Morton & Hall Consulting Limited

Our ref: H7395/RAM/sg/a
Date: 23 December 2021

re: Meadow Lea Cottage, 14 Church Street, Stiffkey

You advised that the Planning Authority had concerns with regard to removal of the rear and side walls at the above site.

ELEVATION 6 - EAST

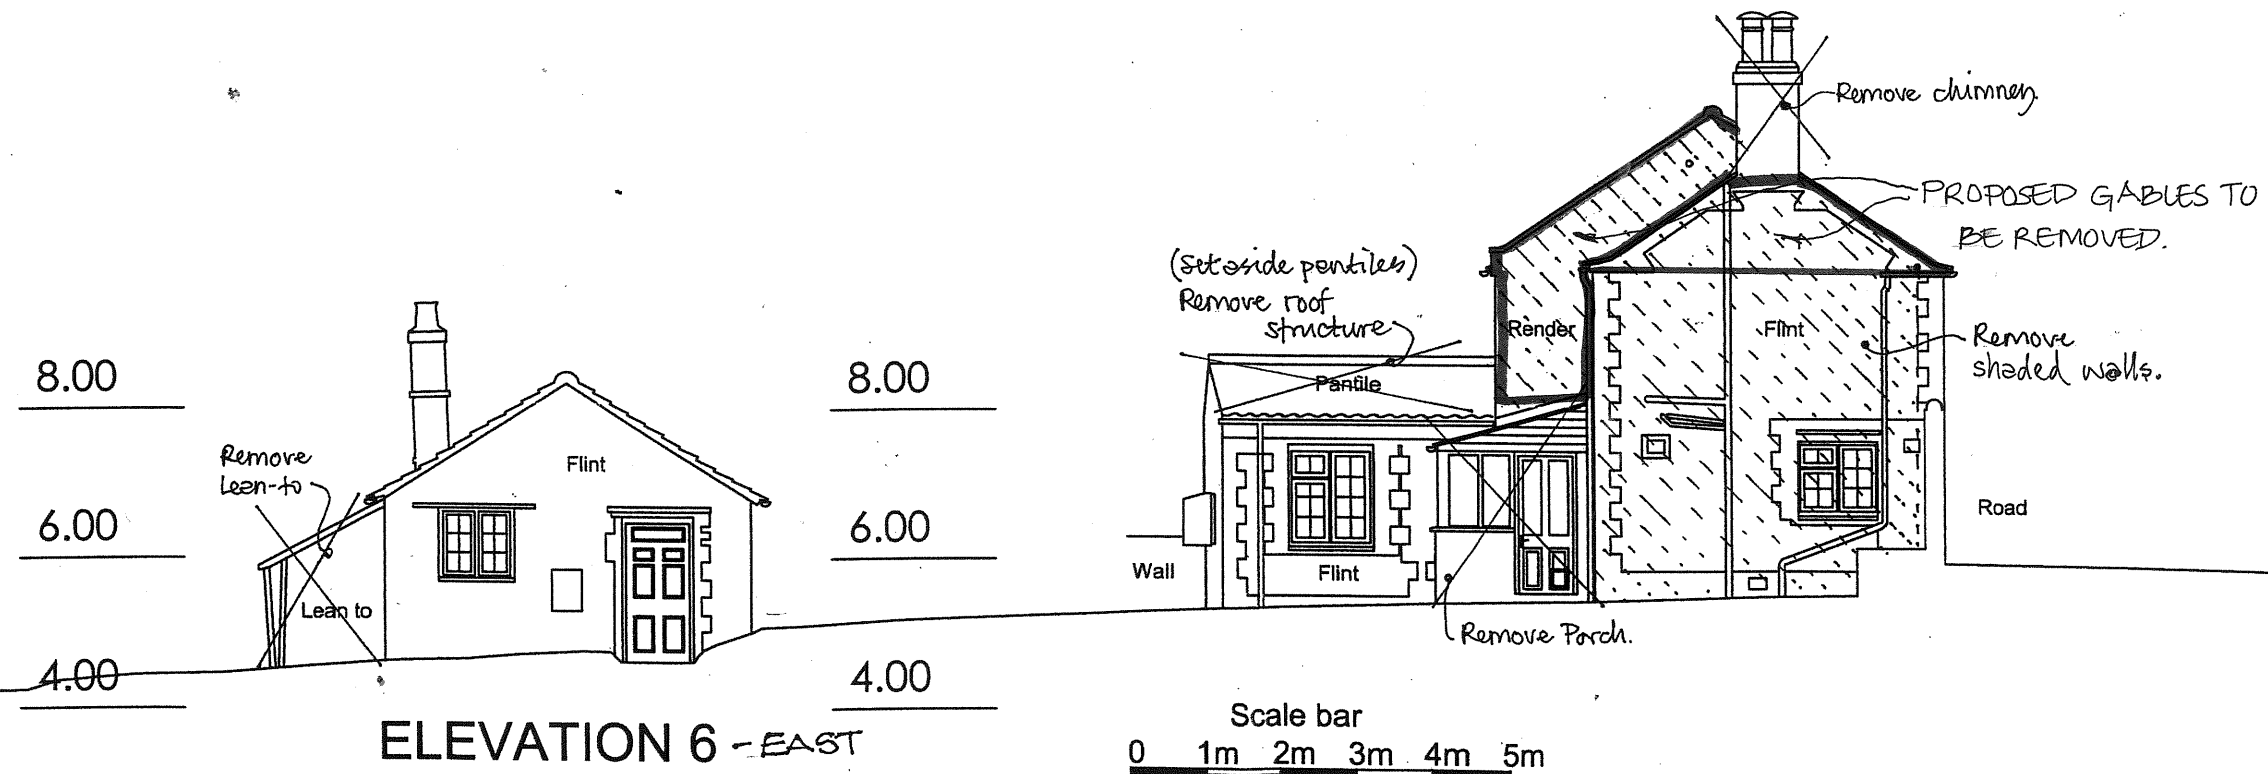
With regard to the east facing gable, there would be such a limited section of wall retained, it would appear pointless to try and keep this wall.

On grounds of Health & Safety also the preferred option would be for demolition and rebuilding.

This has always been the agreed scheme.

EX 01A

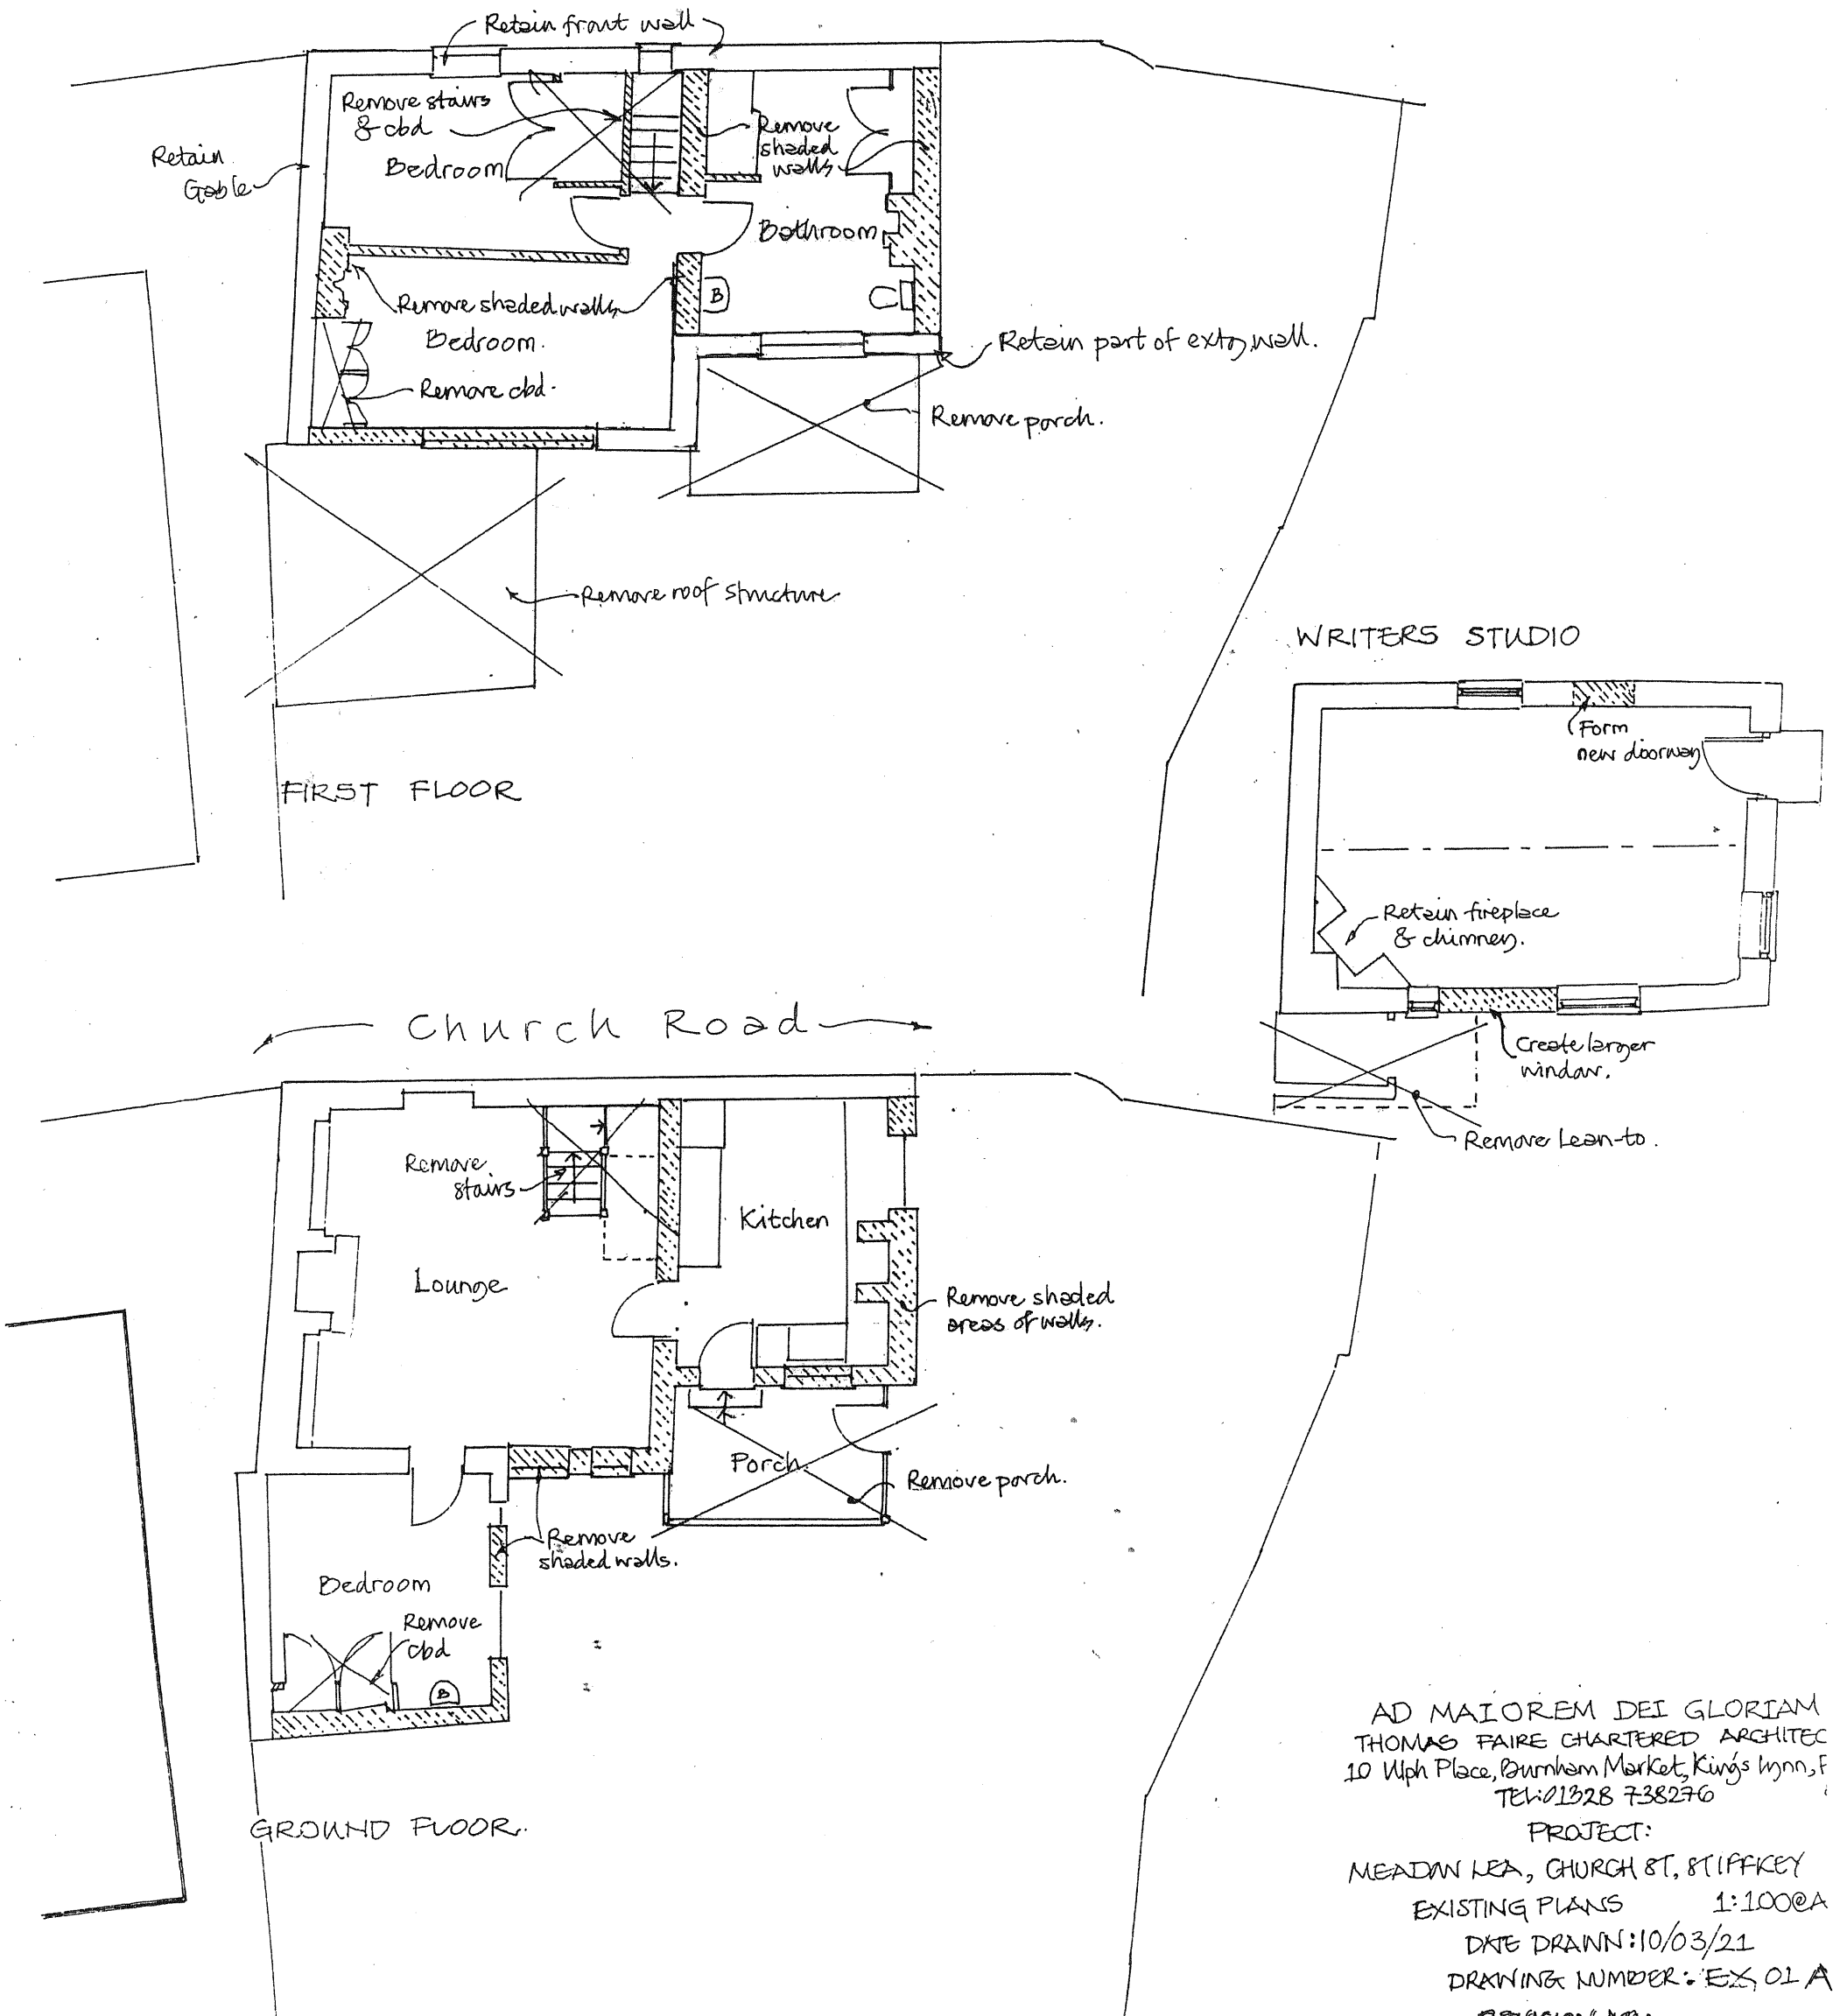
Small sections of the rear return walls would also be far preferable to be removed.

These walls would otherwise require very careful propping whilst underpinning is being made to the front wall and again this would not realistically be feasible in terms of Health & Safety with operatives working at such low levels under.

The facing materials can be salvaged and reset.
